RE: Response to Exhibition of Sydney Opera House (SOH) Building Renewal Program – Concert Hall Upgrade and new Creative Learning Centre (SSD 8663)

ATTACHMENT A: SYDNEY OPERA HOUSE BUILDING RENEWAL PROGRAM

CONCERT HALL & CREATIVE LEARNING CENTRE HERITAGE ASSESSMENT

3 DETAIL DEMOLITION PLAN SUPERSTRUCTURE - EAST PASSAGEWAY

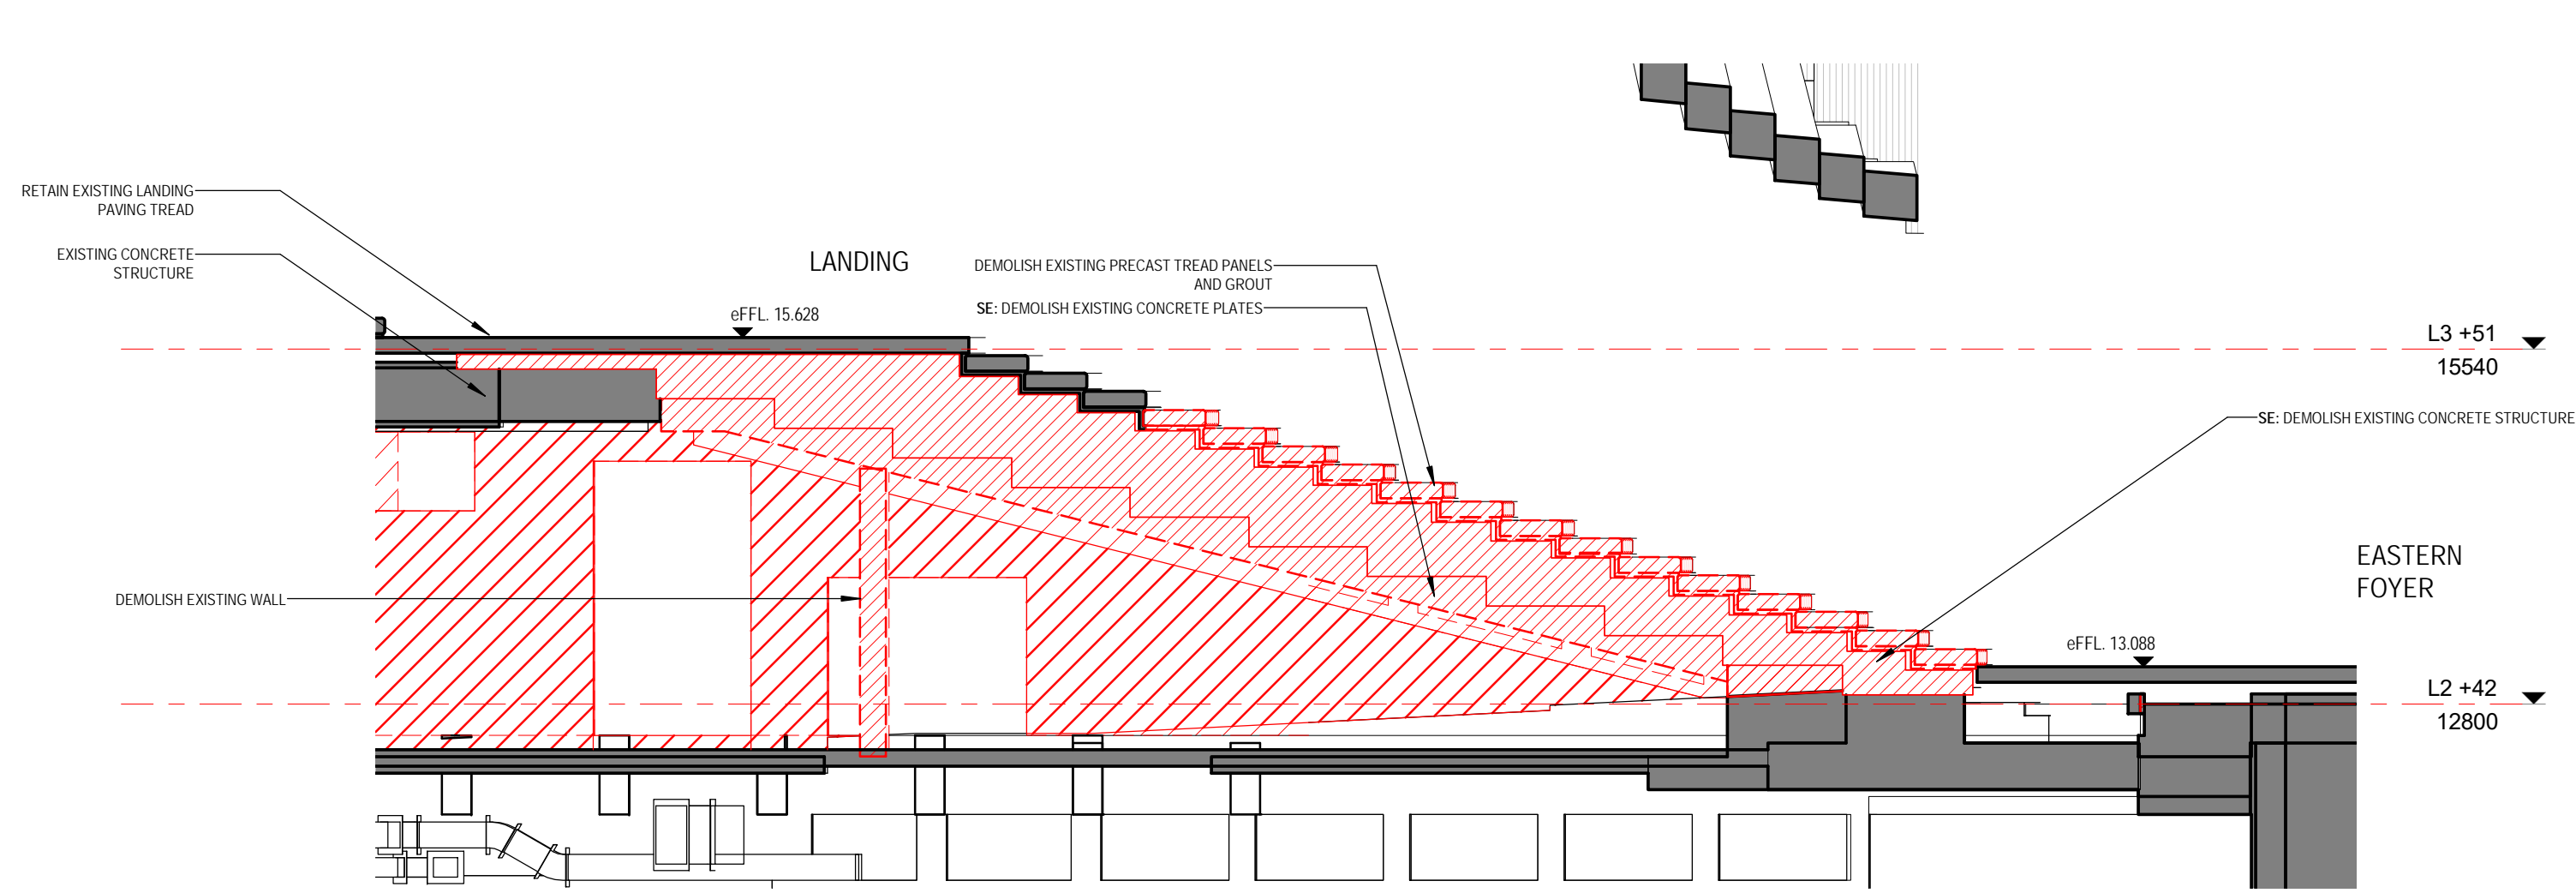
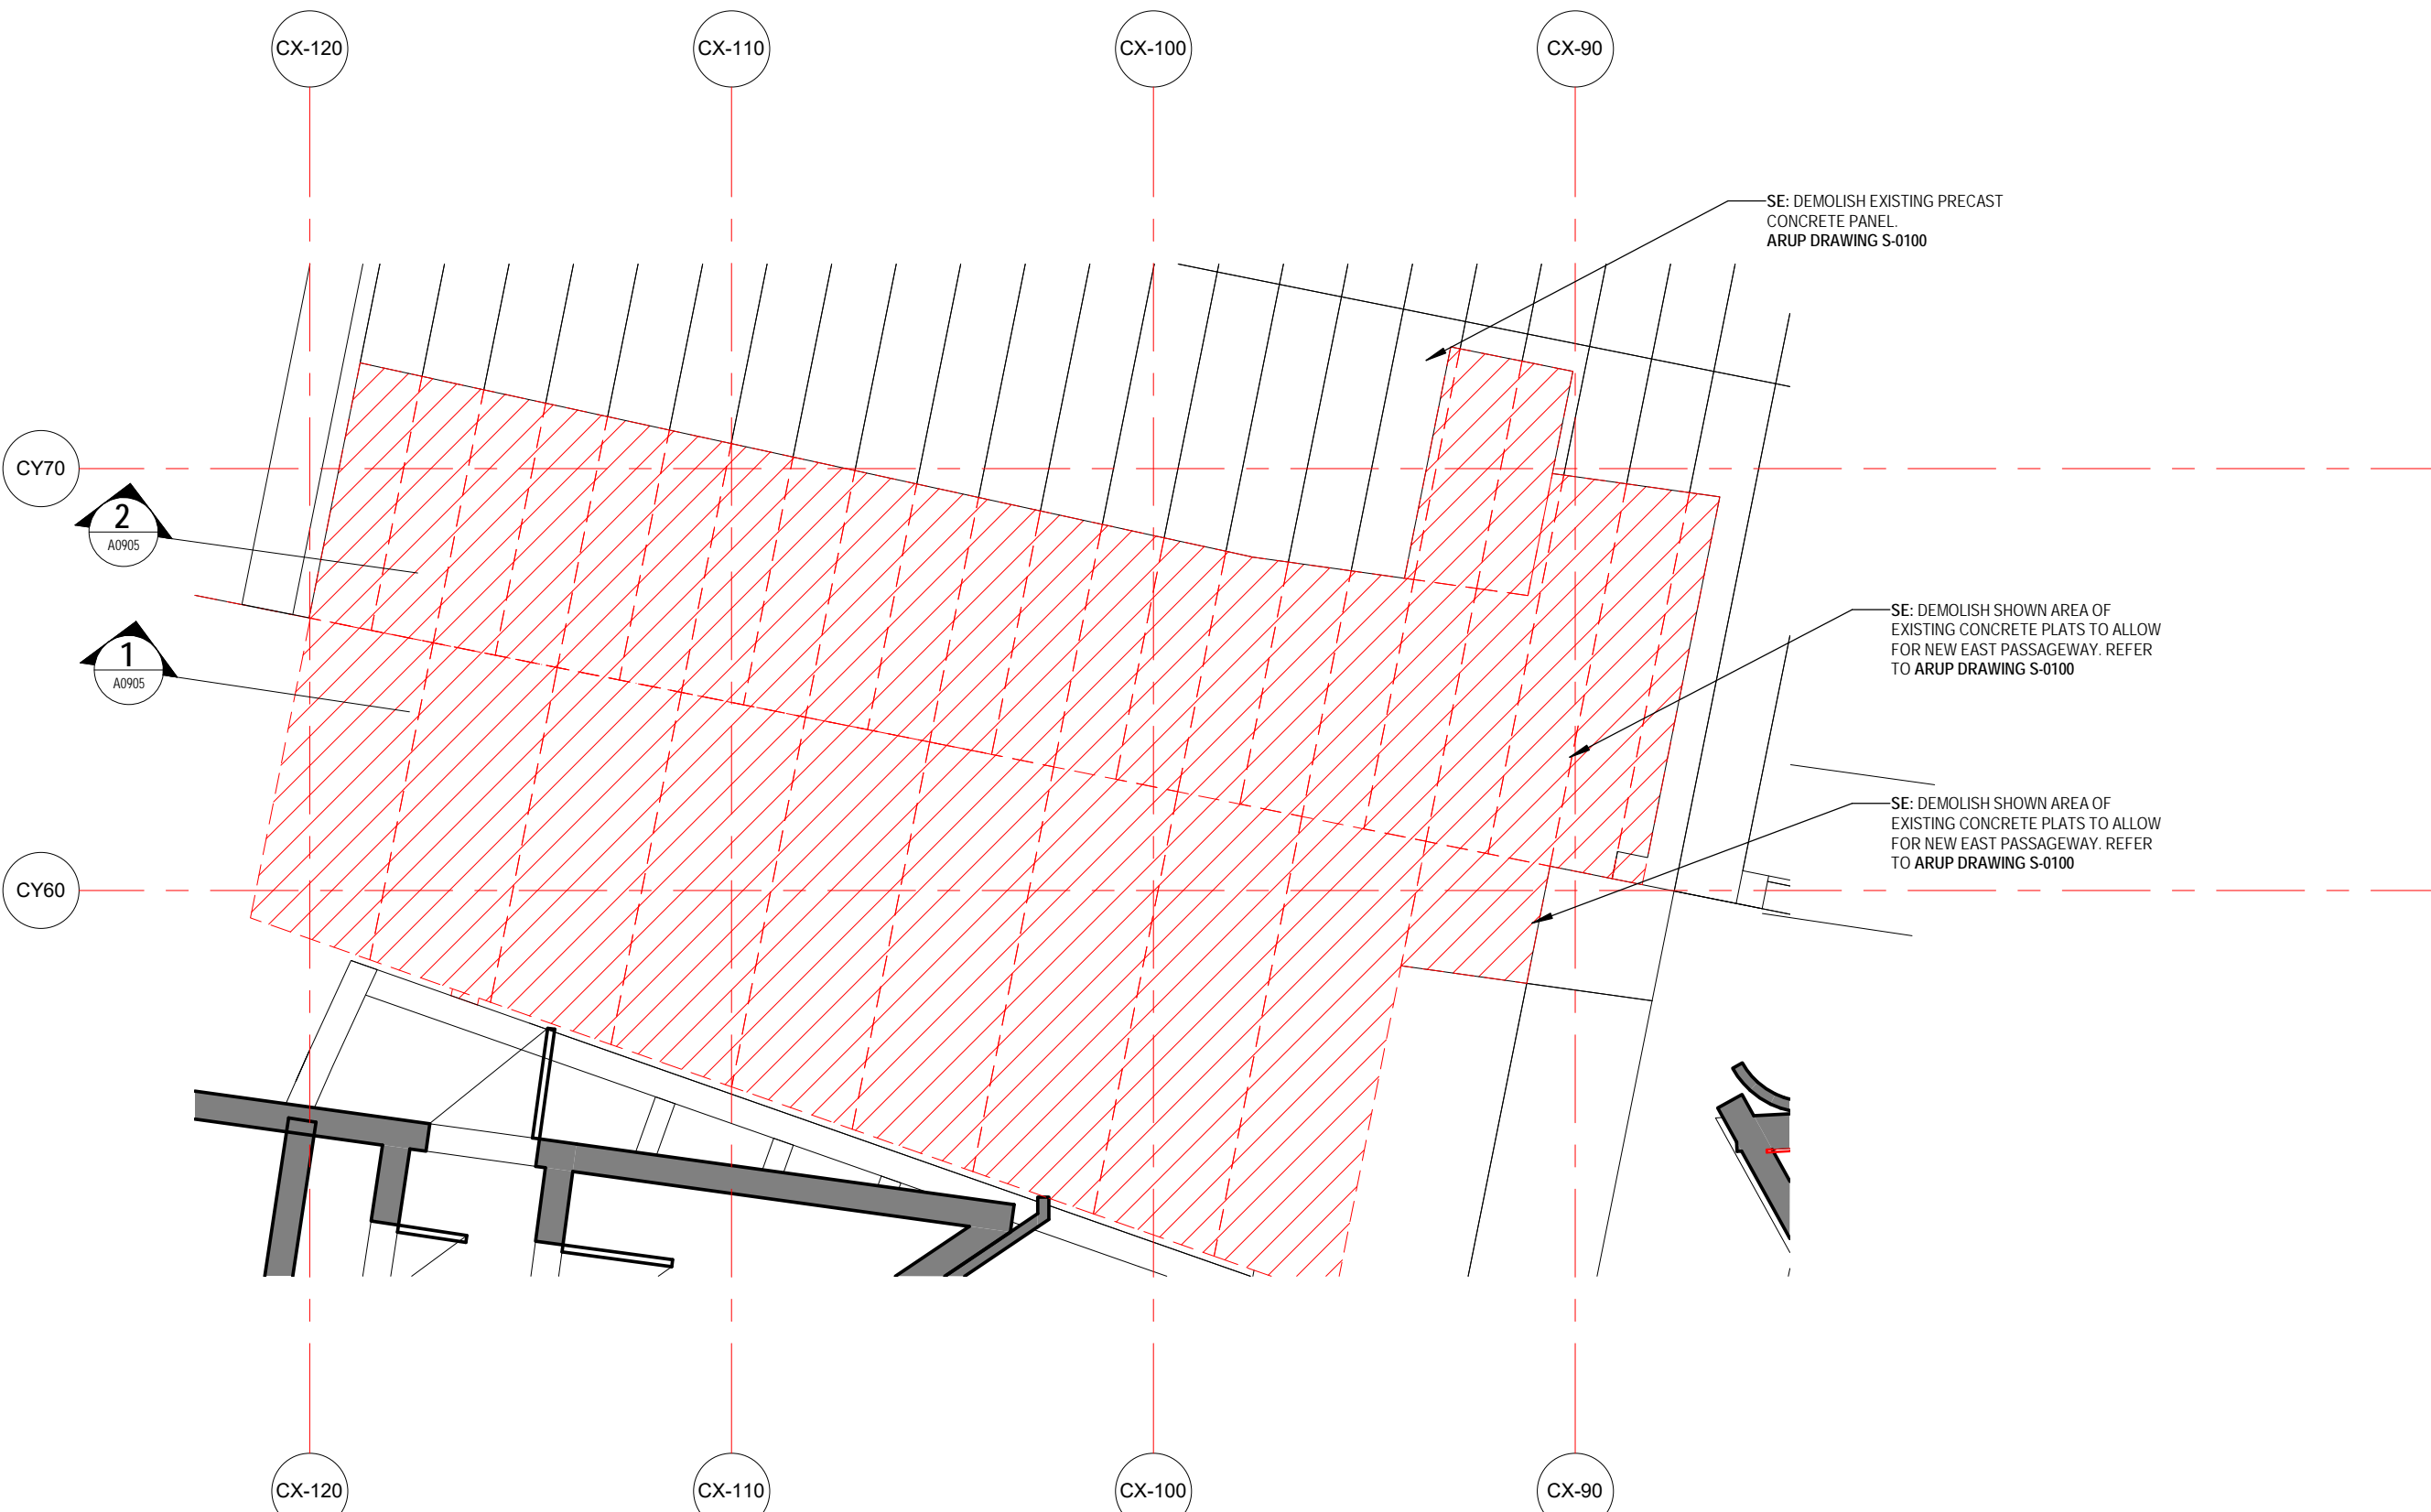
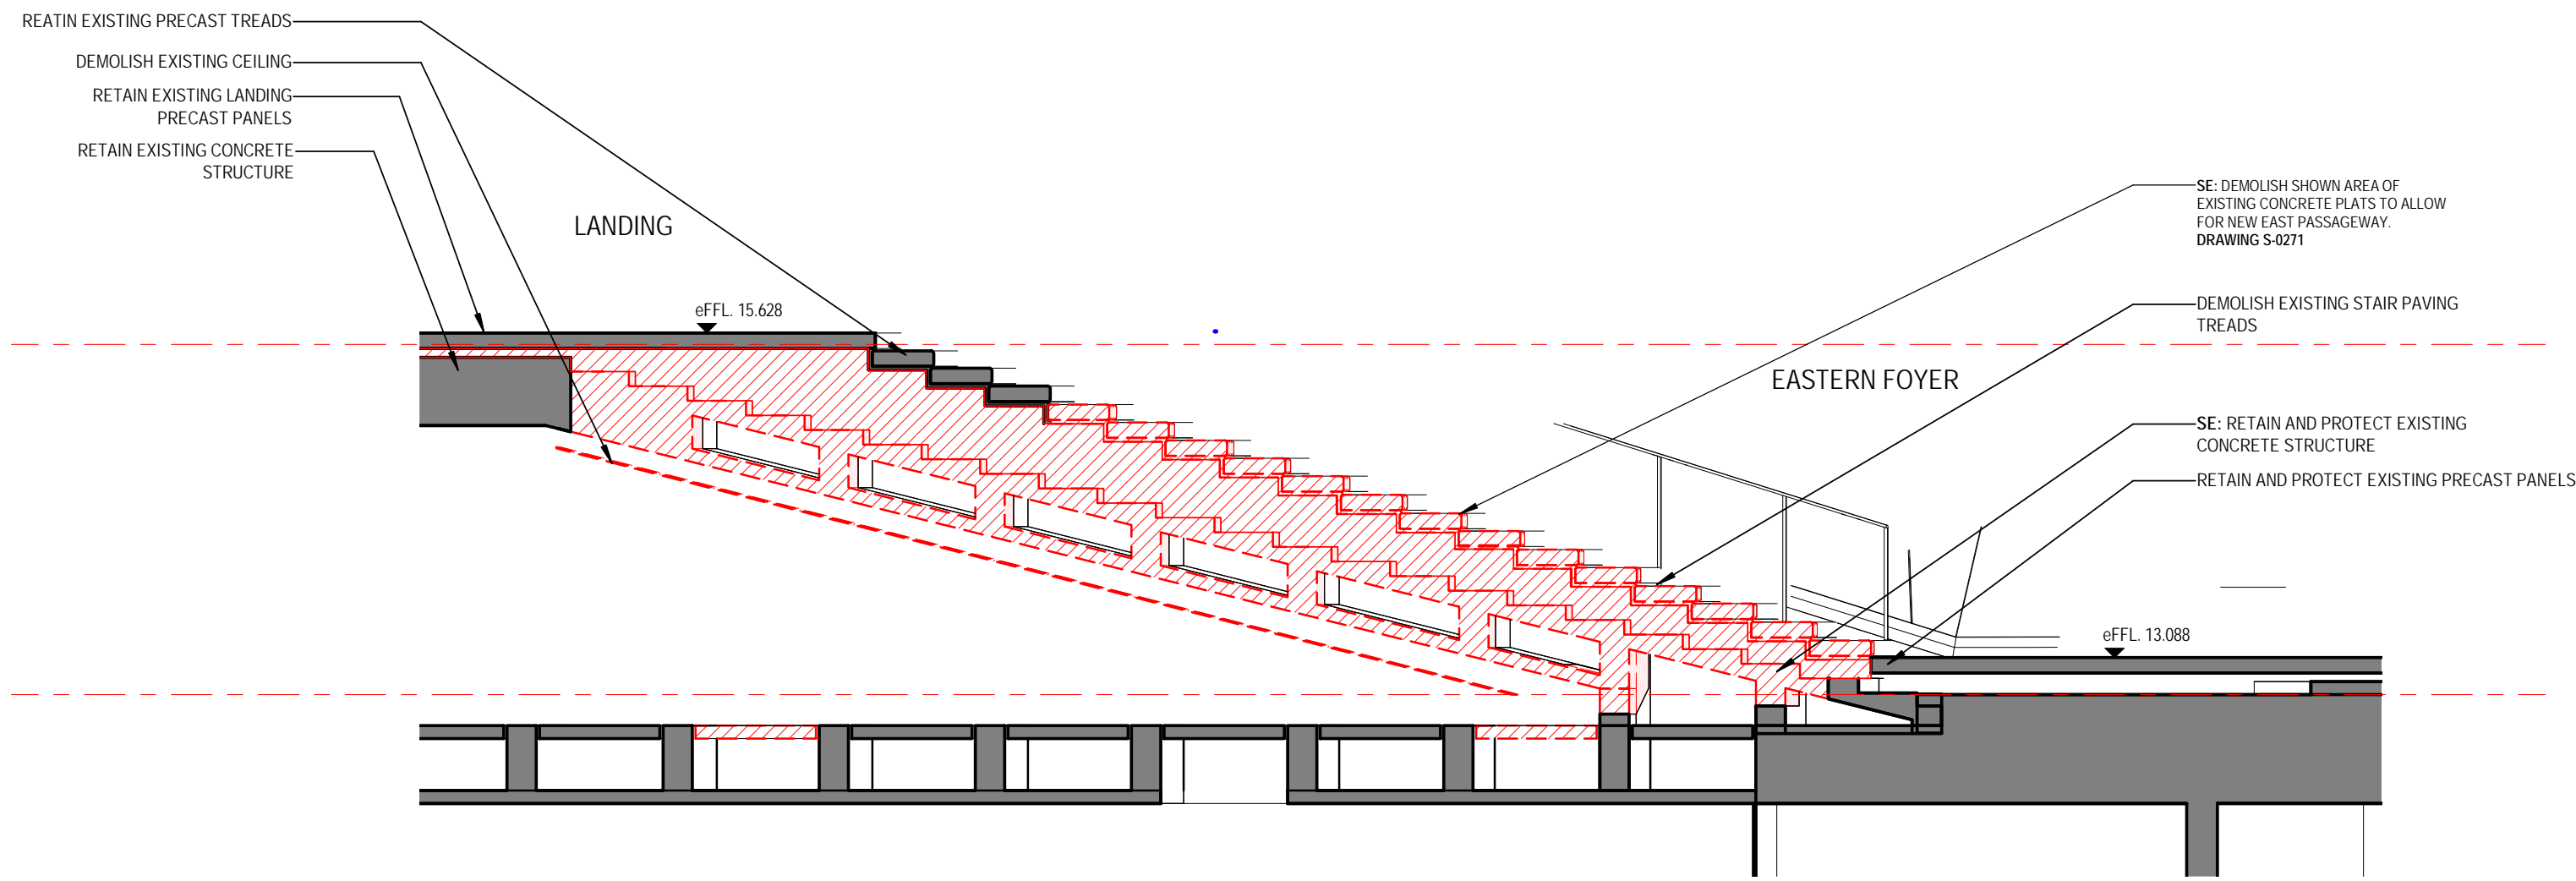
- 3.4 The new passageway entrance is proposed to be located centrally within the eastern foyer stairs. It is noted that the passageway is only proposed on one side of the Concert Hall (eastern), with no works occurring on the western side foyer stairs (apart from new handrails). The proposed location of the passageway entry has high visual impacts as it divides the distinctive broad sweep of stairs which step around the Concert Hall. It also narrows the stair access either side of the passageway and diminishes the grandeur of the space as patrons ascend around the Concert Hall.

- 3.10 The design introduces prefabricated bronze panel elements in a stepped configuration to clad the full length of the eastern wall of the new passage. Whilst the wall configuration reflects the brush box panel cladding of the auditorium in the side foyer above, the use of the bronze material introduces a new design aesthetic to the space. The recent passageway provided to the JST side foyer utilises concrete and timber which is more consistent with the palette of materials used throughout the SOH, and which is also more visually recessive. The extensive use of the bronze panelling in this area is not appropriate and should be reconsidered to better align with the consistent palette of materials of the SOH. The panelling should be more visually recessive.

- 3.12 Bronze panelling is also proposed for the western side of the passageway entry. This should be revised to match an alternative wall cladding to be chosen for the eastern wall.

- 3.14 The proposed works will have an adverse impact on significant form, fabric and structure in this area. The installation of the passageway requires removal of a series of precast granite plank steps and concrete structure below, which will result in a major physical intervention. The steps will be removed in whole lengths (at the expansion joints) and new precast granite steps are proposed to be installed to have finished edges at the junction of the new passageway and the staircase.

- 3.16 The proposed works also involve new concrete finishes. A site visit undertaken by the Heritage Division in January 2019 noted similar works in the JST Side Foyer passageway which were patchy, and the concrete colour mismatched. For some heritage places, it could be argued that the difference in colour identifies new works. However, given that the high-quality finish and detailing in the SOH are integral to its significance, new works must be matched by equal high-quality craftsmanship to ensure the new works are seamlessly integrated into the design. Therefore, any new

- 3.17 The following condition is included in the HIS, *the use of bronze panelling on the southern wall in the Caves area (Level 2) should be tested and reviewed once the other walls are stripped back, by the Opera House's Conservation Council, Eminent Architects Panel and heritage architect, to determine its appropriateness (Pg104)*. However, the extensive use of bronze panelling within the passageway introduces a new design aesthetic to the space. A panelling treatment consistent with existing panelling used within the SOH should be proposed in consultation with the Heritage Council to ensure the 'natural' visually recessive palette of materials and colours is retained and respected.

- 3.18 Any new steps installed must match the existing in both form and finish. This should be determined in consultation with the nominated heritage consultant working closely with an experienced precast concrete craftsperson to ensure colour and form are matching. Removed fabric should be retained, modified and reused where possible.

- 3.19 Any new elements proposed, including concrete finishes, must match the existing in both form and finish. This should be determined in consultation with the nominated heritage consultant working closely with an experienced concrete expert to ensure seamless consistency, to the satisfaction of a Heritage Council delegate.
